Subject: RE: FP/57/19/PL - The Malthouse Restaurant, Waterloo Road, Felpham

DRAWING TITLE:
Proposed Floor Plans

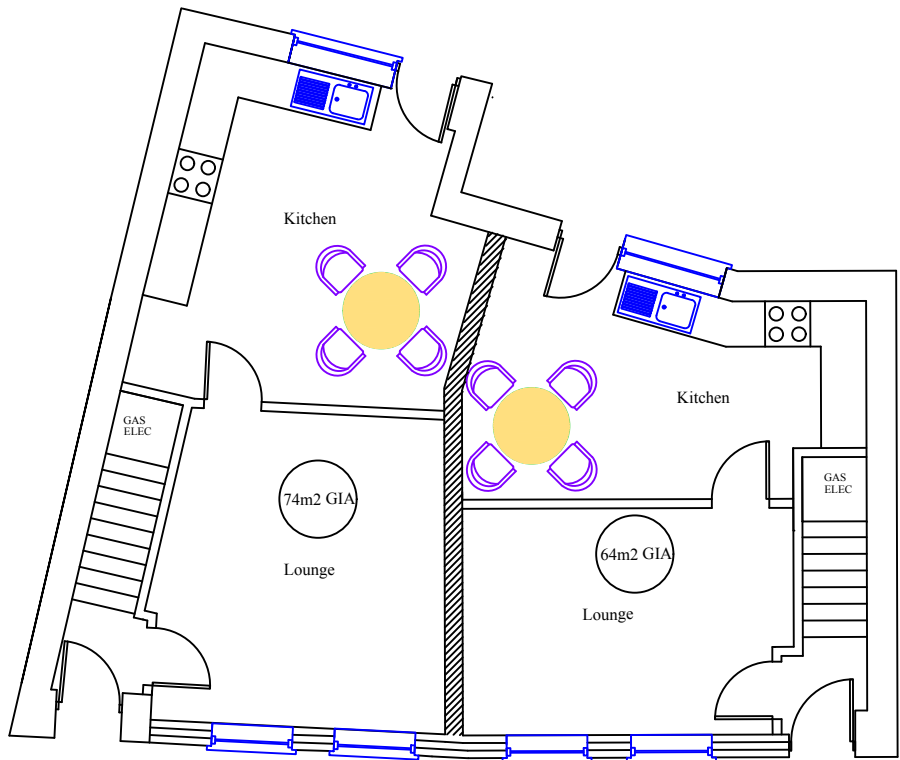
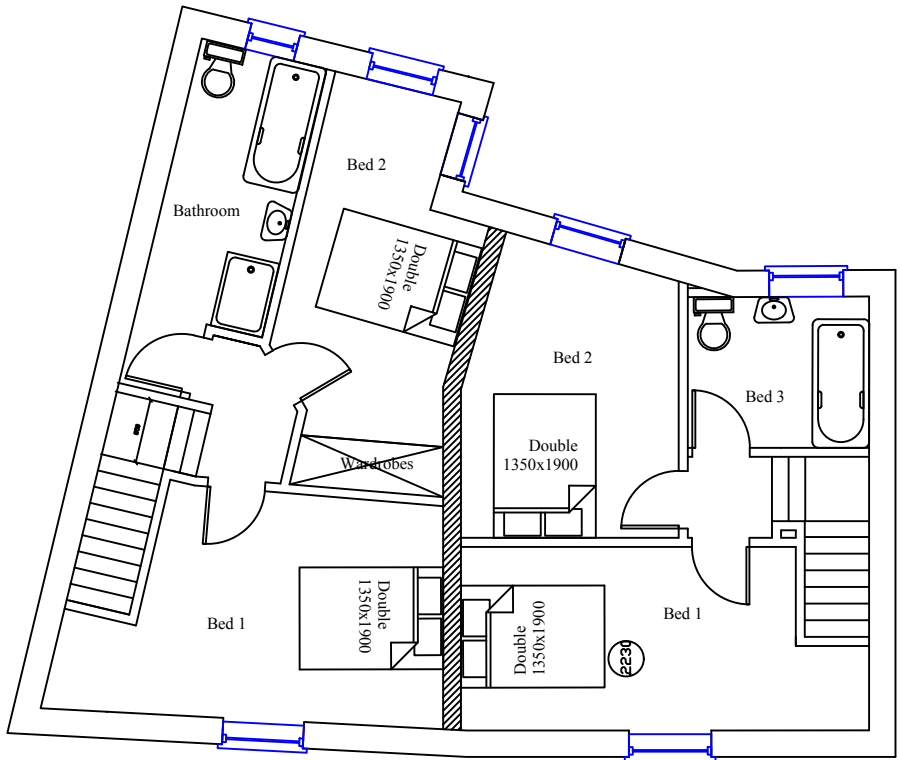
I also have a slight concern regarding space standards in that both flats are shown as having 2 double bedrooms but one of them is only 64m² in area. The required standard for a 2 bedroom, 4 person dwelling is 70m². However, can you confirm the actual size of the bedrooms as it may be the case that if a bedroom is less than 11.5m² in area then for the purposes of the standards it is treated as a single. Two bedroom, 3 person dwellings require only 61m².
